Appeal Decision

Appeal Ref: APP/R4408/D/21/3281775

4 Meyrick Drive, Darton, Barnsley S75 5PL

- The appeal is made under section 78 of the Town and Country Planning Act 1990 against a refusal to grant planning permission.
 - The appeal is made by Mr & Mrs Lee Horbury against the decision of Barnsley Metropolitan Borough Council.
 - The application Ref 2021/0567, dated 16 April 2021, was refused by notice dated 09 June 2021.
 - The development proposed is: Proposed front dormers.
-

Drawing Title: As Proposed Elevations and Plans

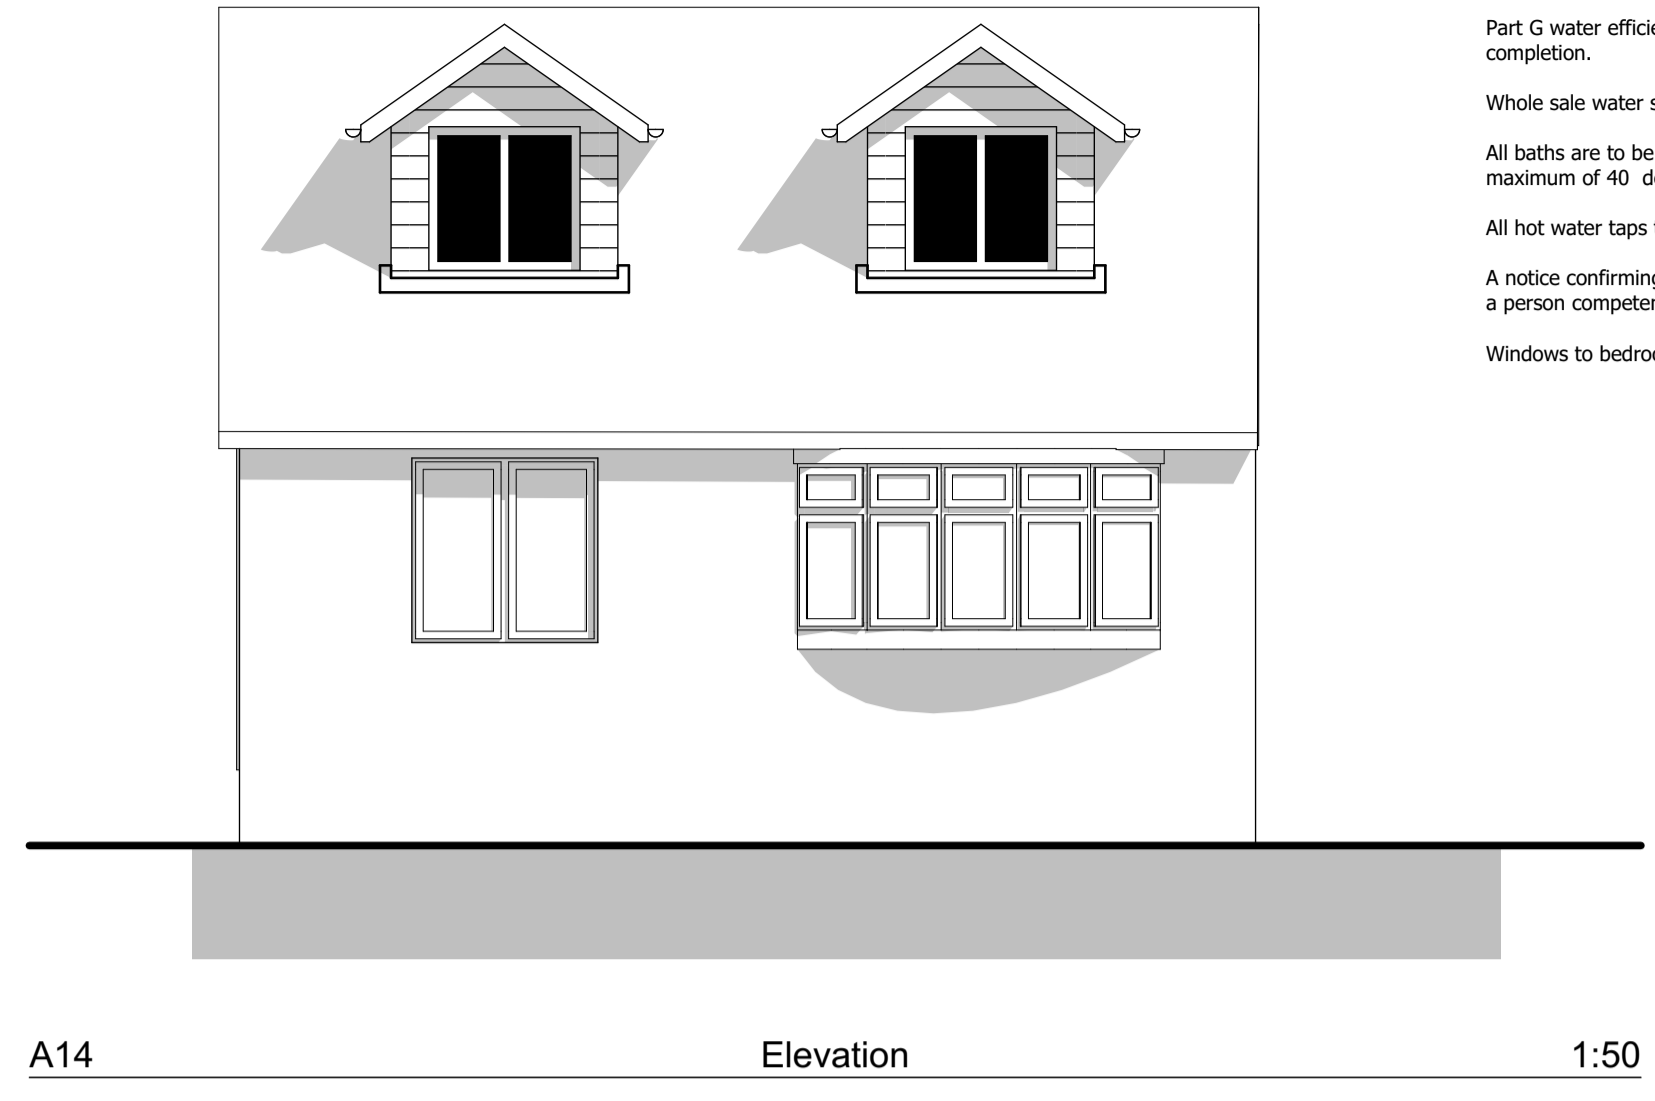
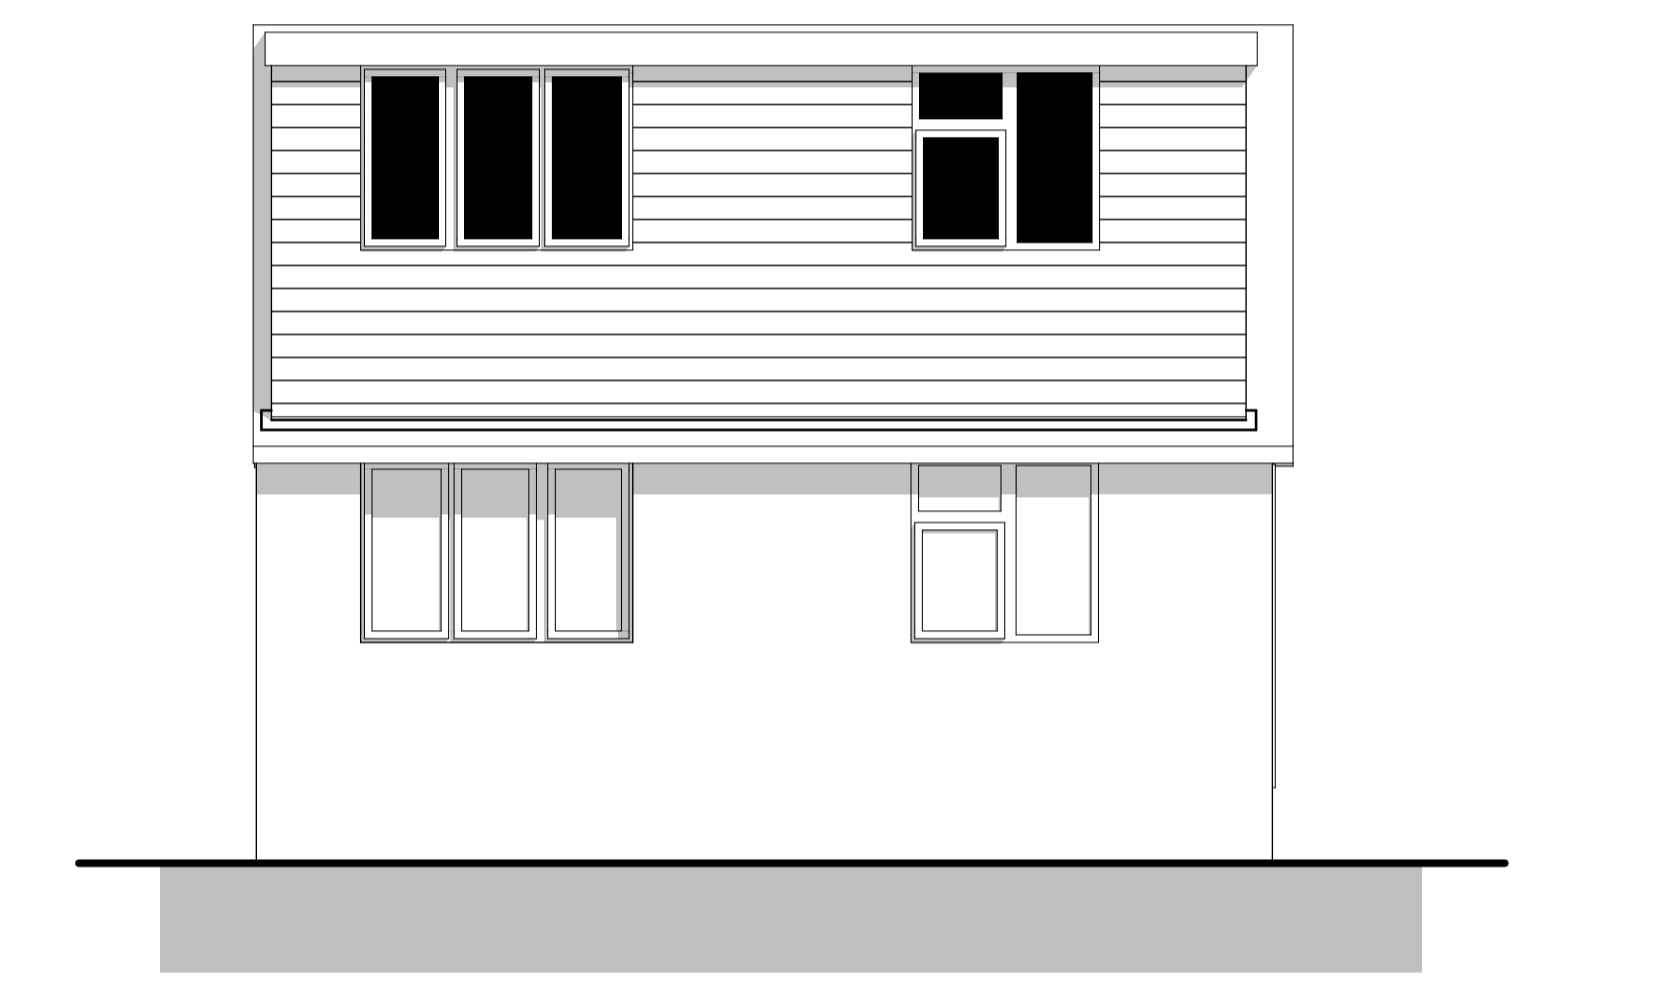
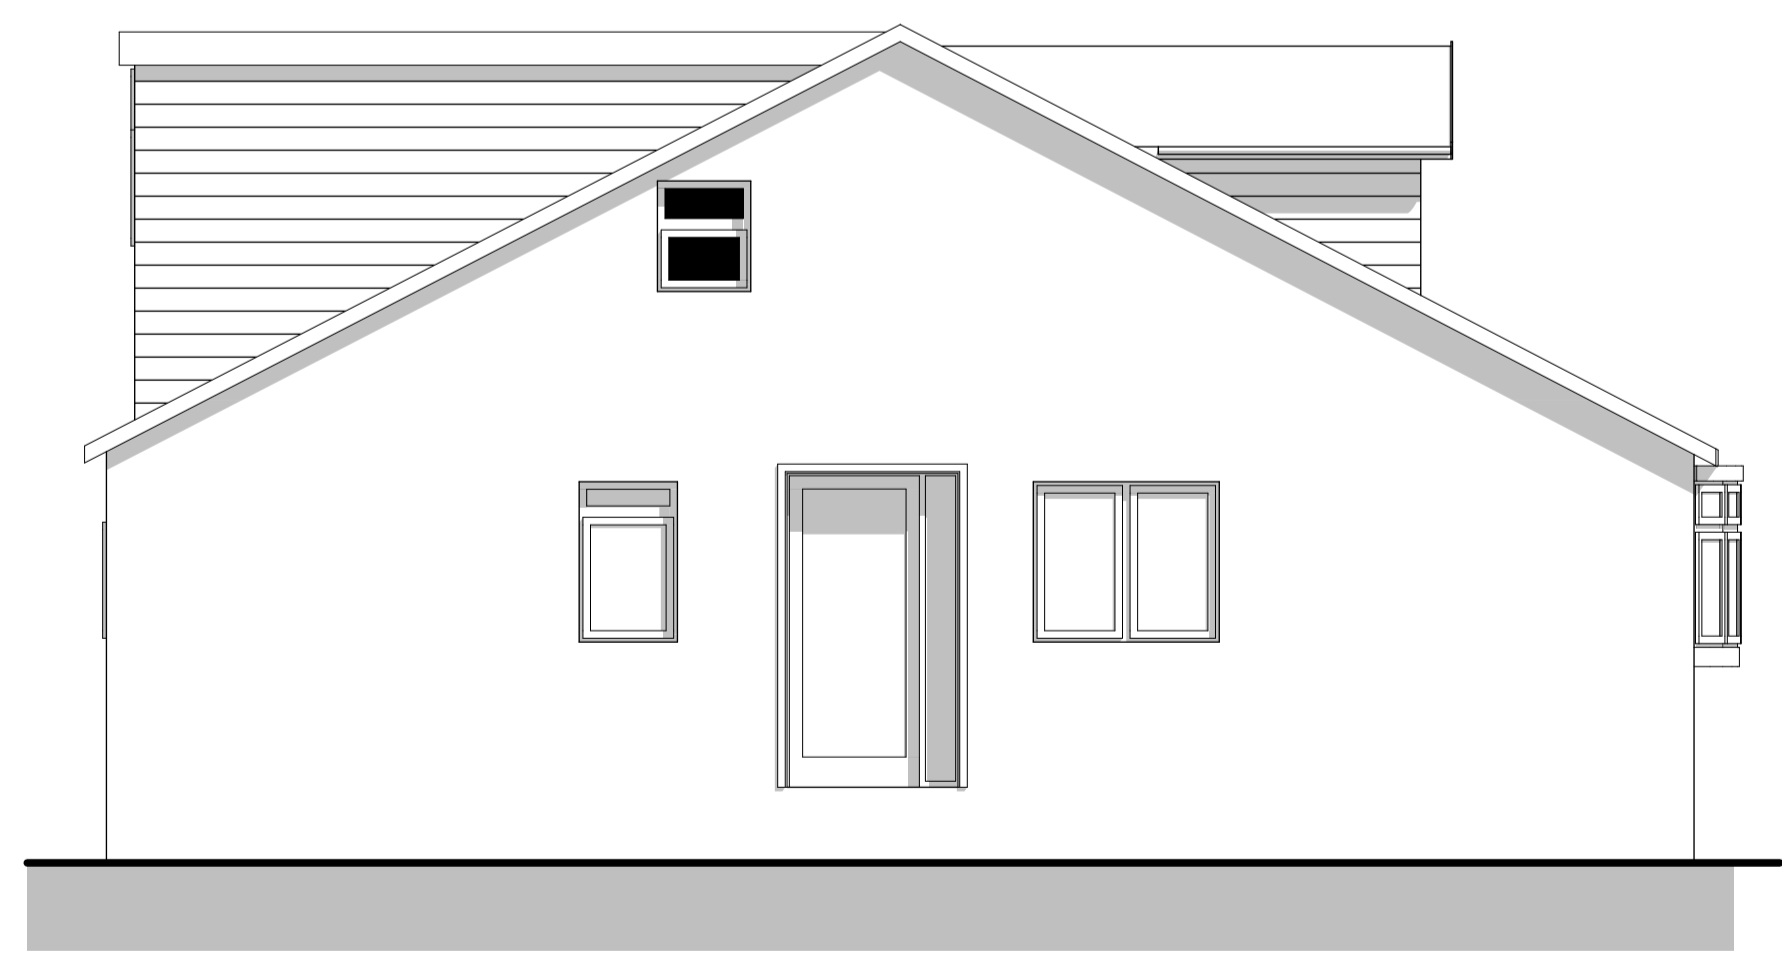
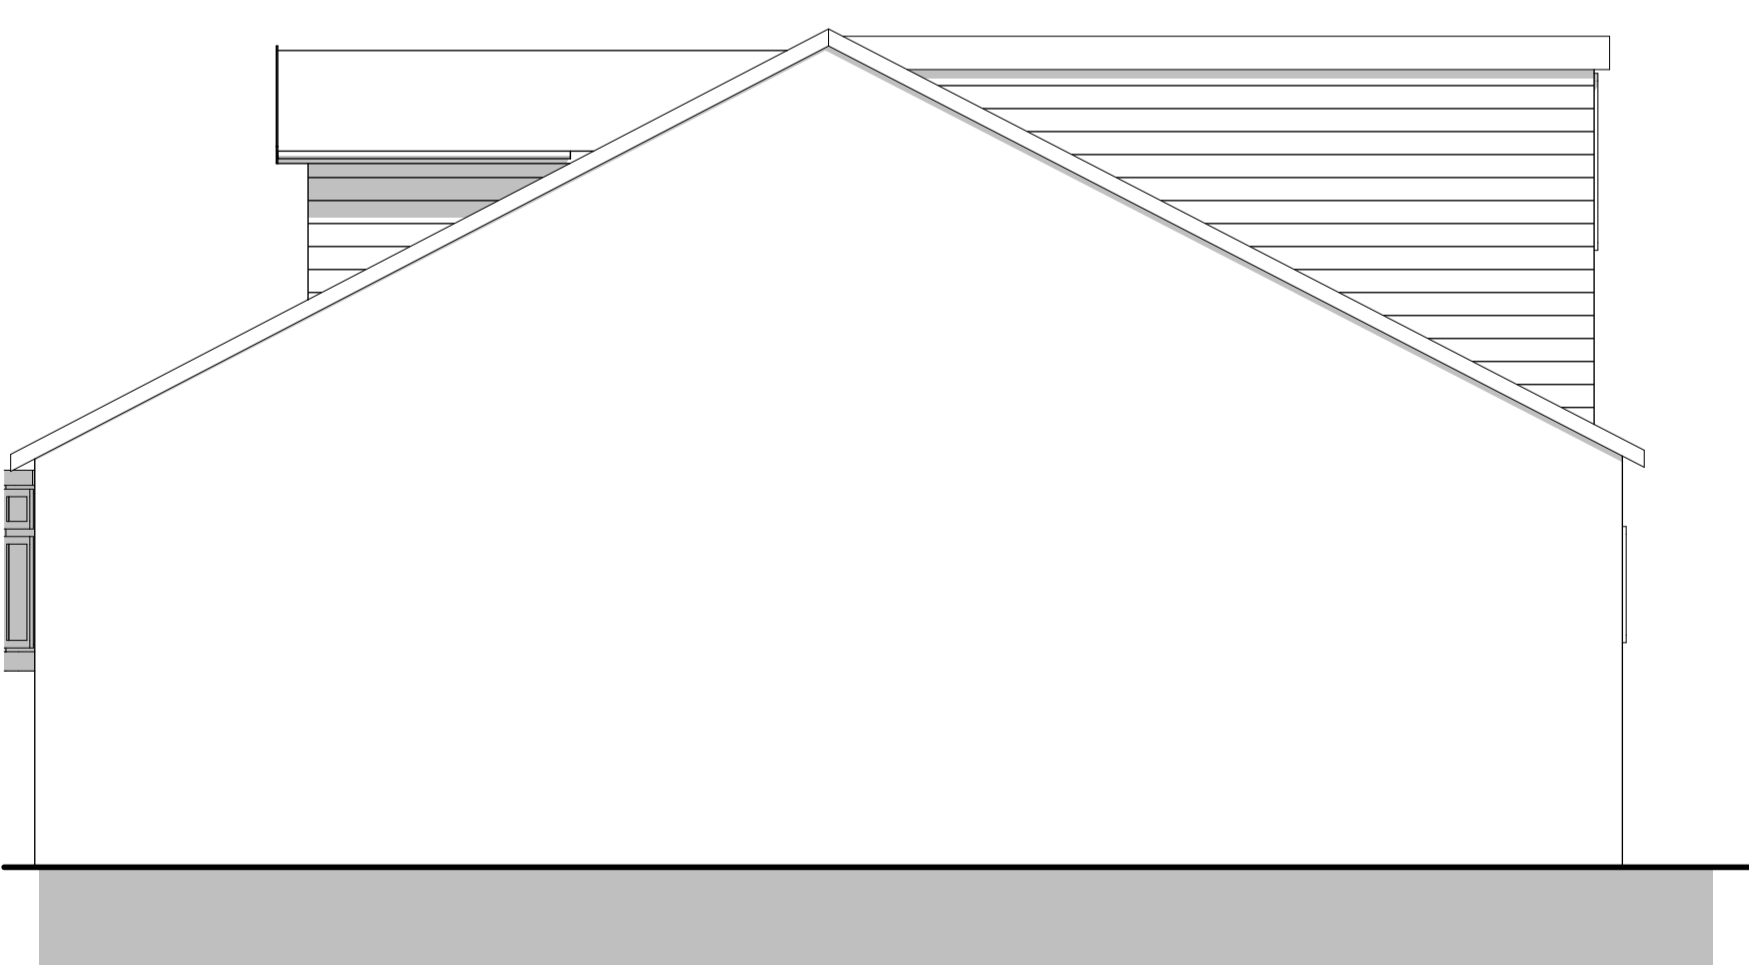
2. The description of development given on the application form was 'proposed front dormers' and the appellant's appeal statement confirms that 'the application the subject to this appeal was for the construction of two dormer windows to the front facing roof slope'. However, the proposed plans also depict a rear dormer which is not currently in situ and the Council altered the description of proposed development on the decision notice to 'Dormers to roof'. The delegated officer report identifies that the Council considered the rear dormer to form part of the proposal.

3. It is not clear if the Council unilaterally changed the description or if there was any correspondence with the appellant over the matter, as is required. Notwithstanding the fact that a rear dormer is also depicted on the drawings, it seems clear that the application sought permission for the front dormers only and I have proceeded on that basis.

6. The proposed front dormers would disrupt that uniformity and add clutter to the prominent roofline and would appear as an incongruous addition given the hitherto unaltered design. I recognise that an attempt has been made to design the dormers sensitively, through the use of pitched roofs, setting in the dormers from the eaves and sides of the property, and alignment to match the fenestration at ground floor level. Nonetheless, those measures would not overcome the jarring impact when set against the pleasing consistency of the front elevations of the bungalows when seen from public vantage points in the street.

7. Whilst dormer windows are present on properties further down Meyrick Drive, there is a distinct change in character between the older bungalows and more modern 'mock Tudor' properties in the cul-de-sac at that end of the street. The Council's House Extensions and Other Alterations Supplementary Planning Guidance (2019) states that to assess whether dormer windows will be appropriate on the front or principal elevation the roofs of surrounding buildings should be examined. Whilst dormers are present in the modern development at the end of the cul-de-sac, they are notably absent from the run of bungalows of which the appeal site forms a part. Architecturally and visually, the appeal site undoubtedly relates to the surrounding bungalows rather than the modern estate. The two parts of the street have very separate and distinct characteristics and do not read as one entity. Having regard to the distinct design of the bungalows the proposal would represent an alien and harmful addition. The fact that the Council approved dormer windows elsewhere in different contexts, as in the examples referred to by the appellant, does not alter my conclusion in that regard.

8. In view of the above the proposal would represent poor design that would fail to reflect local character, contrary to the aims of policy D1 of the Barnsley Local Plan (2019) and the design related aims of the National Planning Policy Framework, particularly paragraph 130(c) which requires new development to be sympathetic to local character and the surrounding built environment.
